**wilbar associates ltd**  
HIGHWAY CONSULTANTS

**Transport and Highways Review**  
**Application No: P/58/19/PL**  
**Rear of Inglenook Hotel 253-255 Pagham Road**  
**Pagham PO21 3QB - Erection of 9 No. dwellings with**  
**associated access, parking, cycle & refuse storage**  
**& landscape design**

Refuse Vehicle
Swept Path Analysis

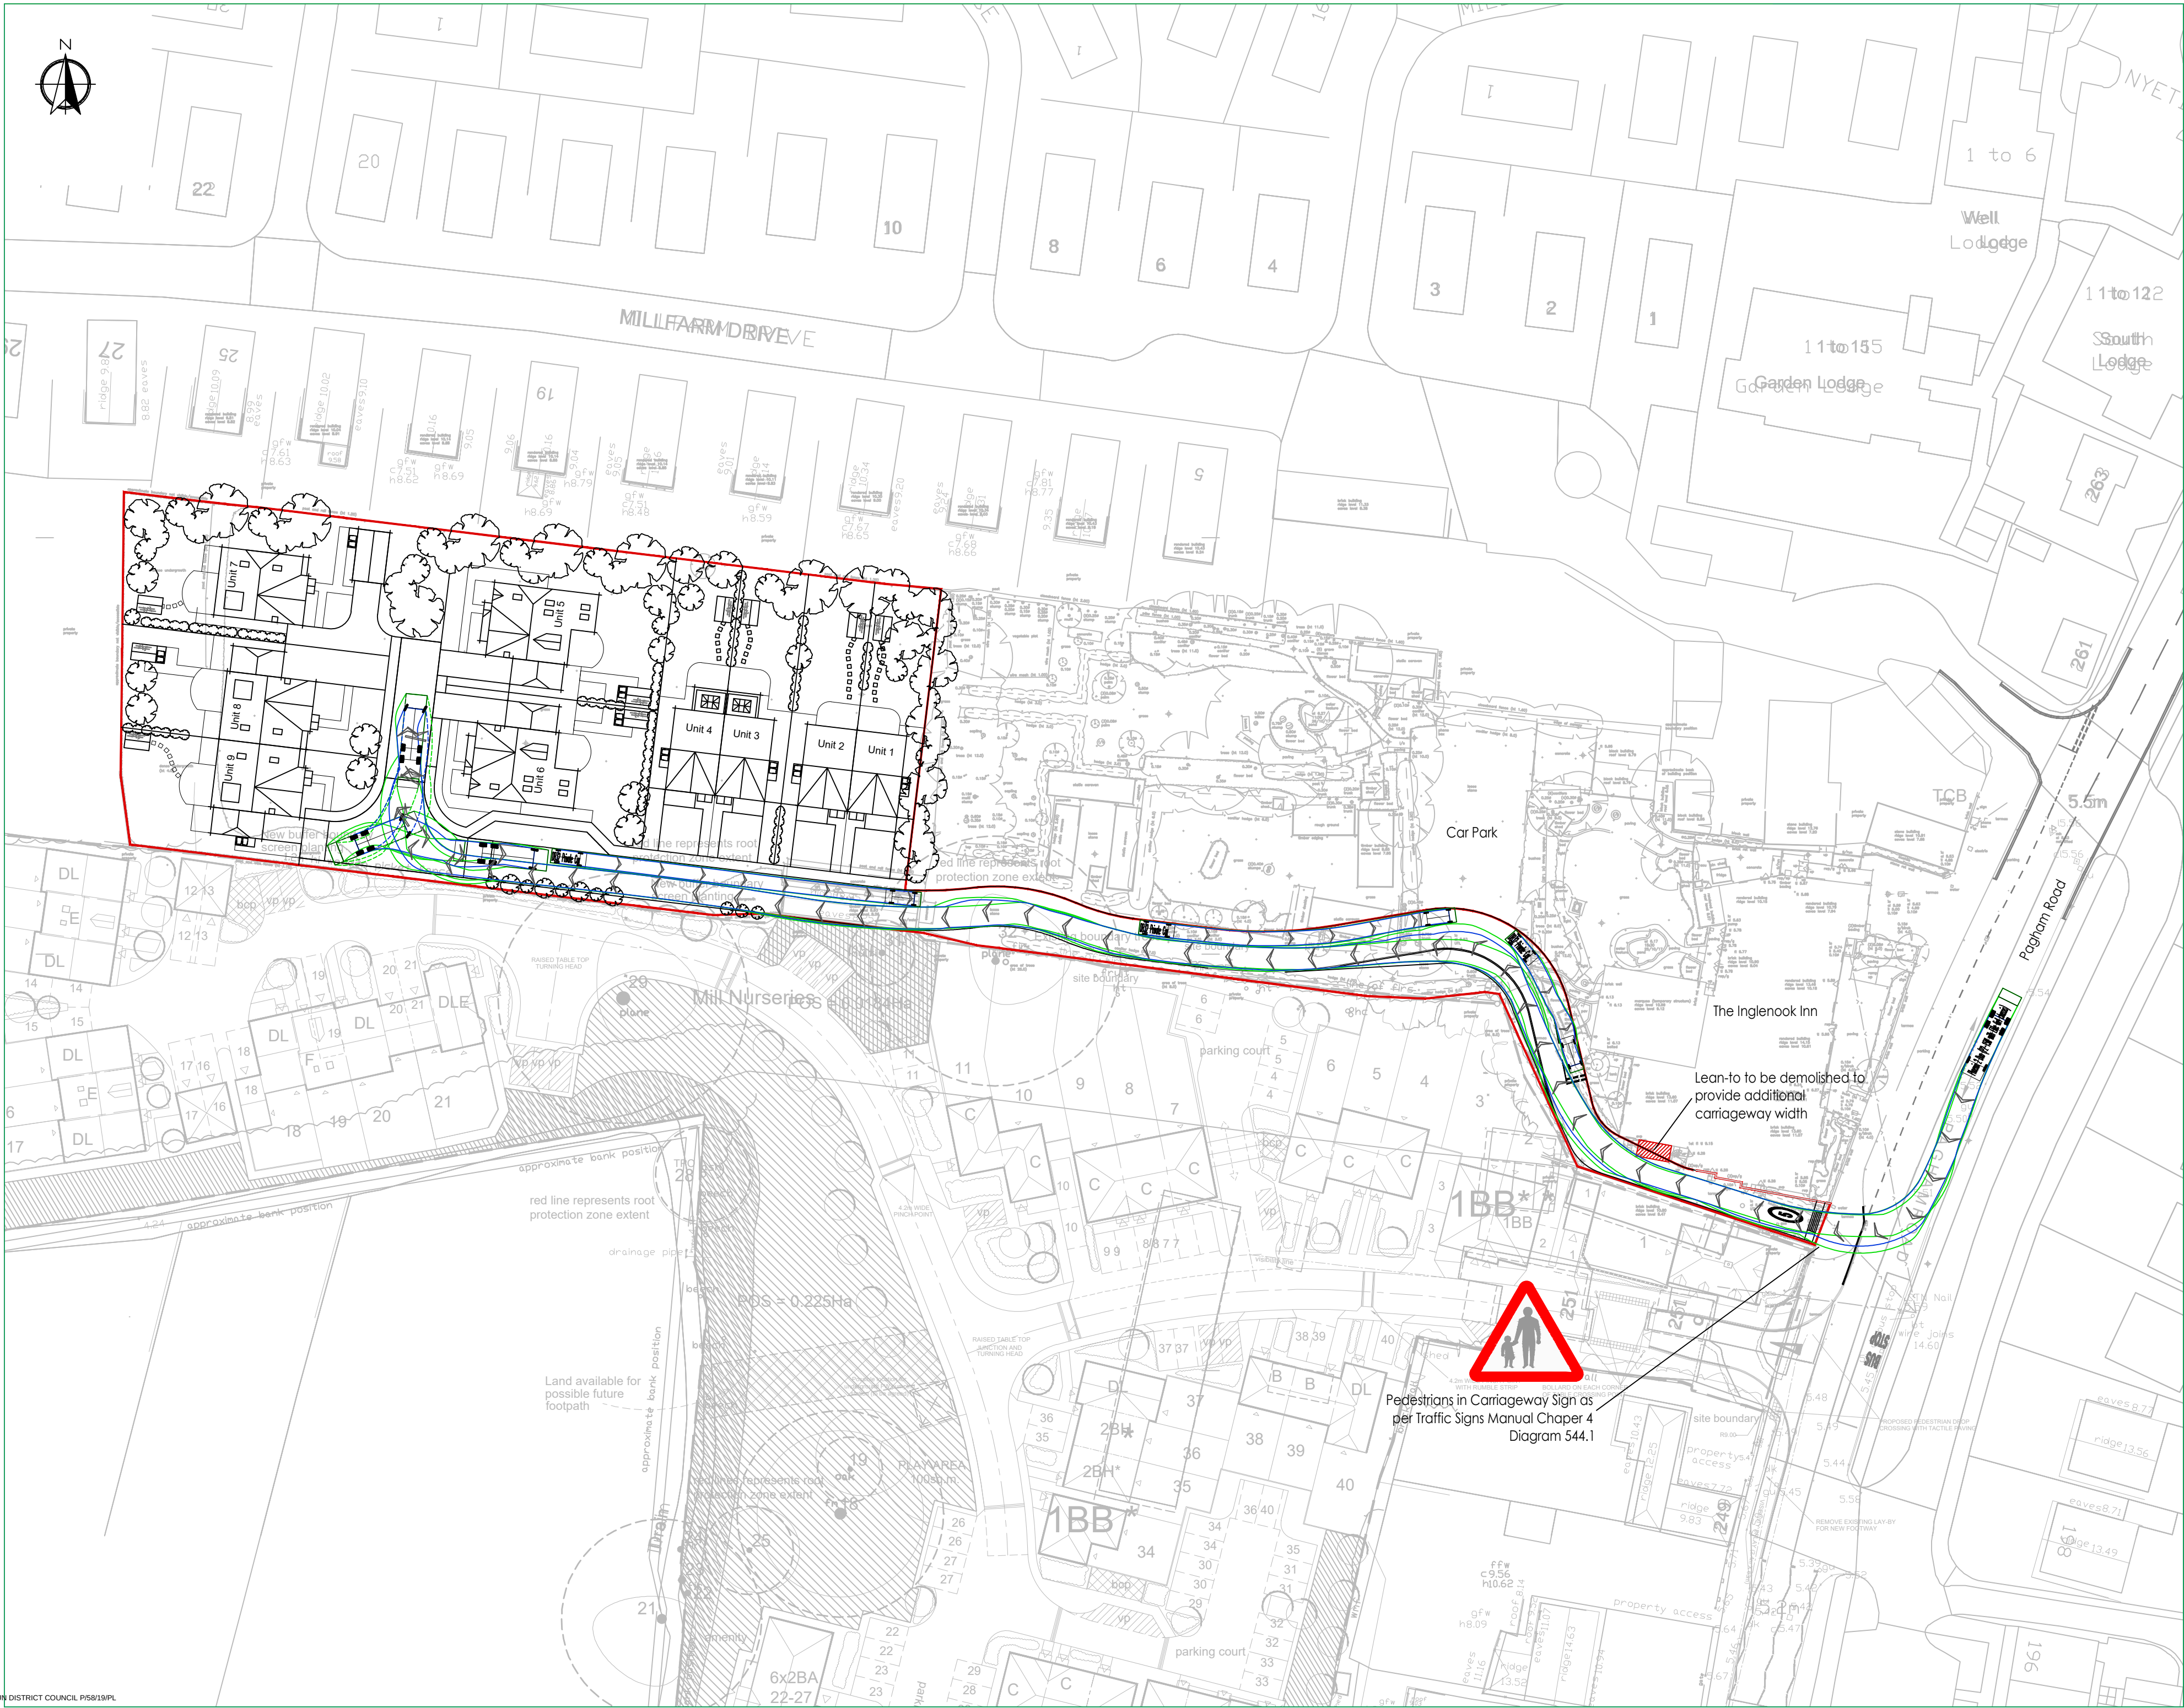
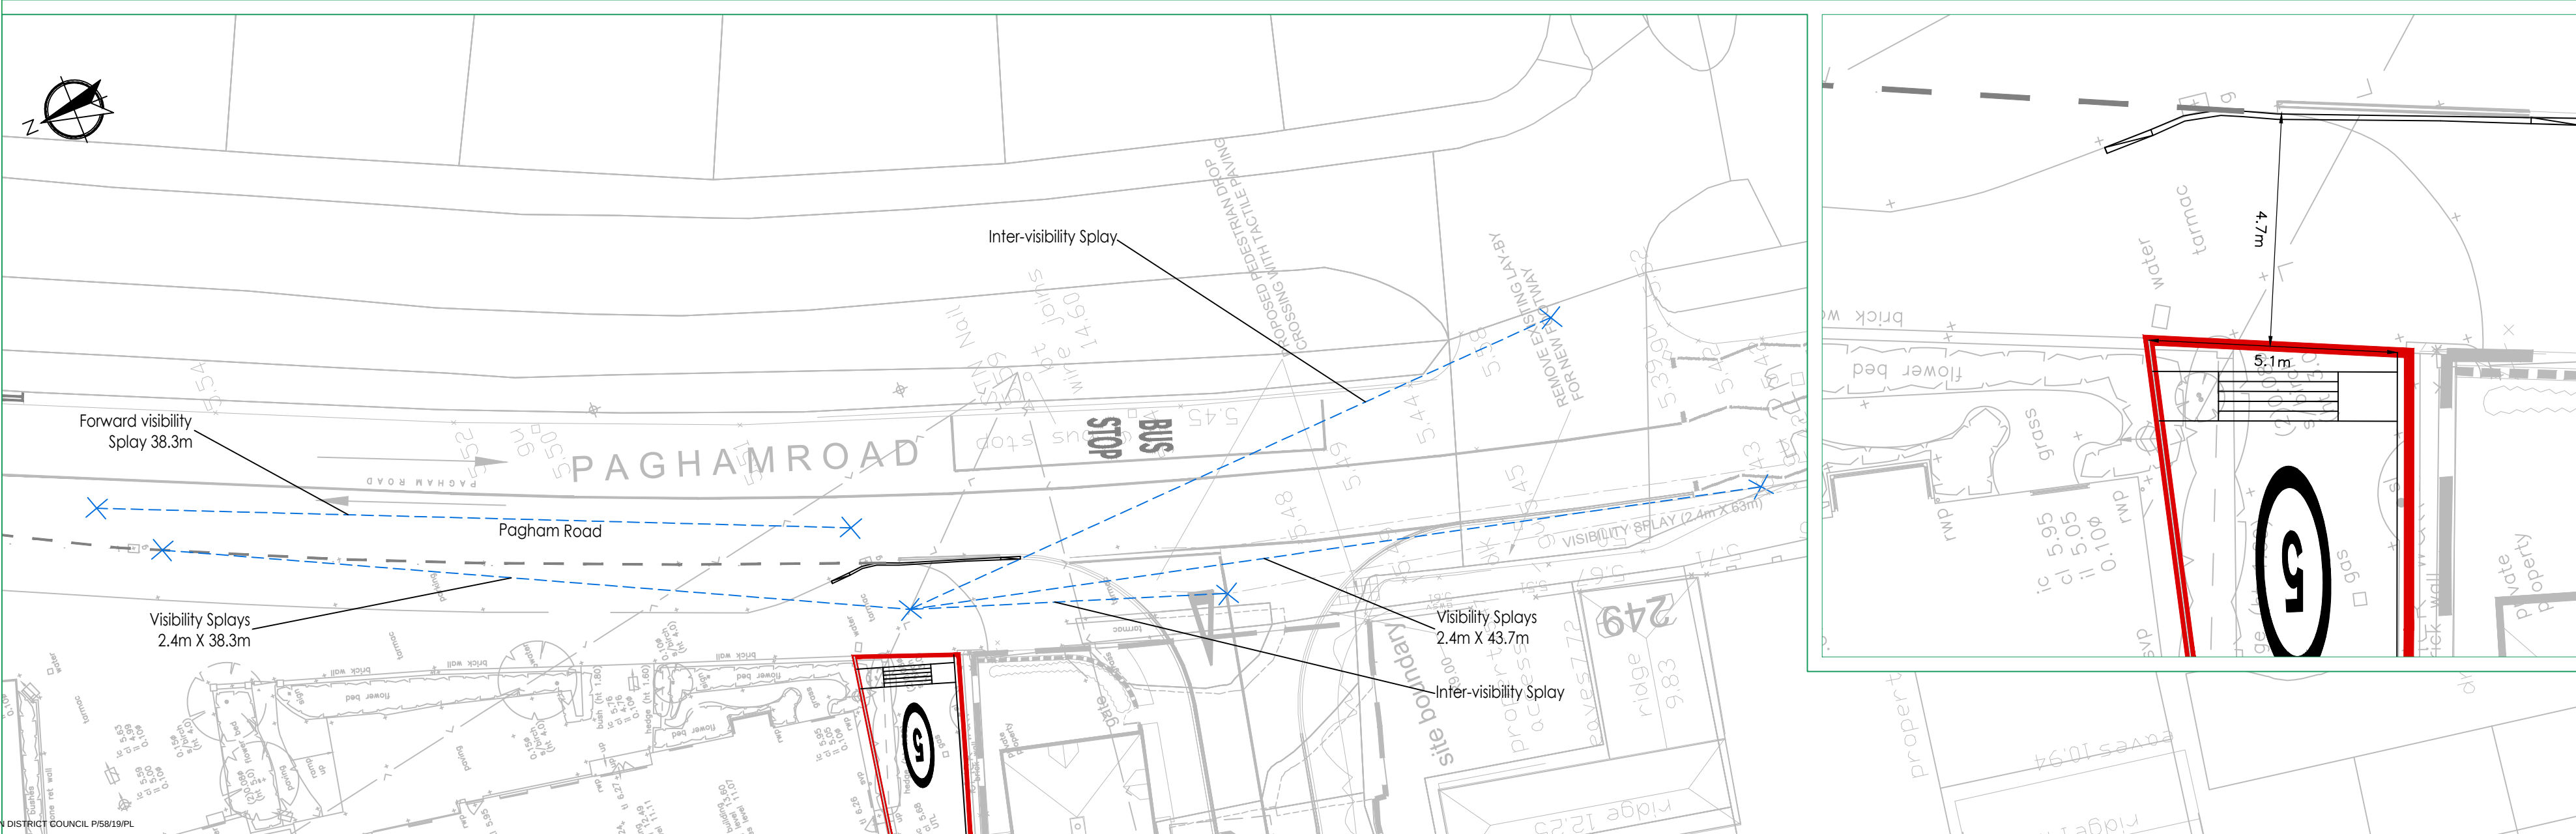
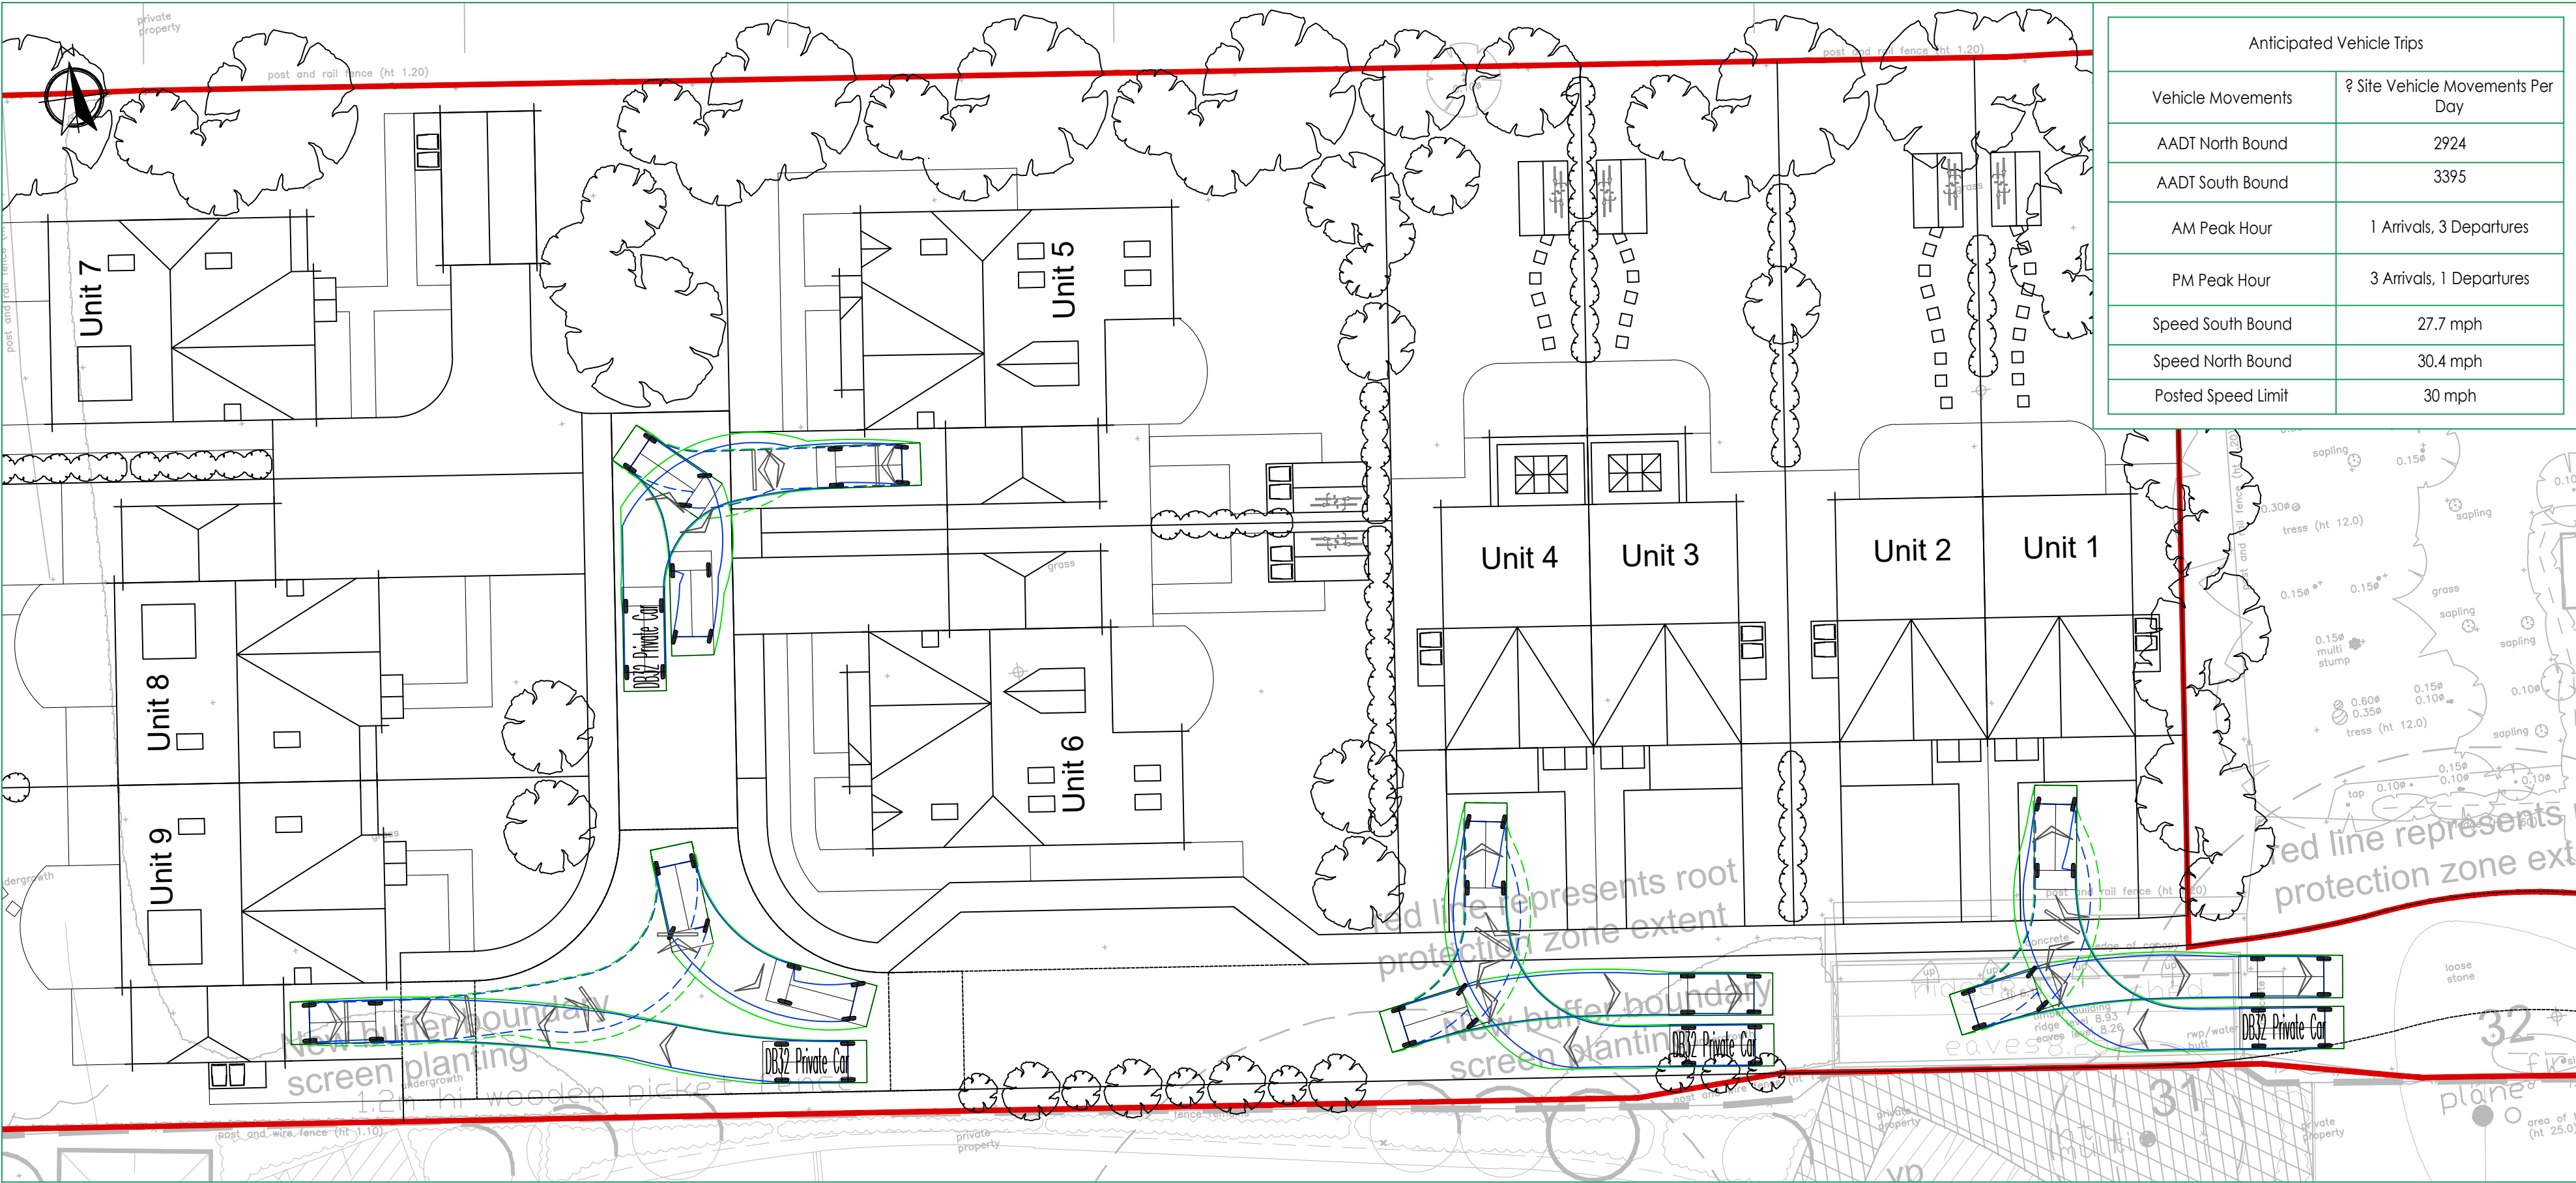
- 5.1.5 The existing access road requires modifications to enable access for refuse vehicles, emergency vehicles and increase in the number of cars. The Transport Statement states that there is a pinch point of 3.8 metres 10 metres within the access road that will be widened to 4.8 metres with the loss of an outbuilding as shown on Drg. No. 2017-3763-001 Rev A in the Transport Statement. Figure 5.7 below shows the location on the access road, looking further the swept path if very close to lamp columns and steps with no margin

of error. There is further widen along the access road to maintain a constant width of 4.8 metres and impacts on the static caravan site, paths and buildings relating to the Inglenook Hotel.
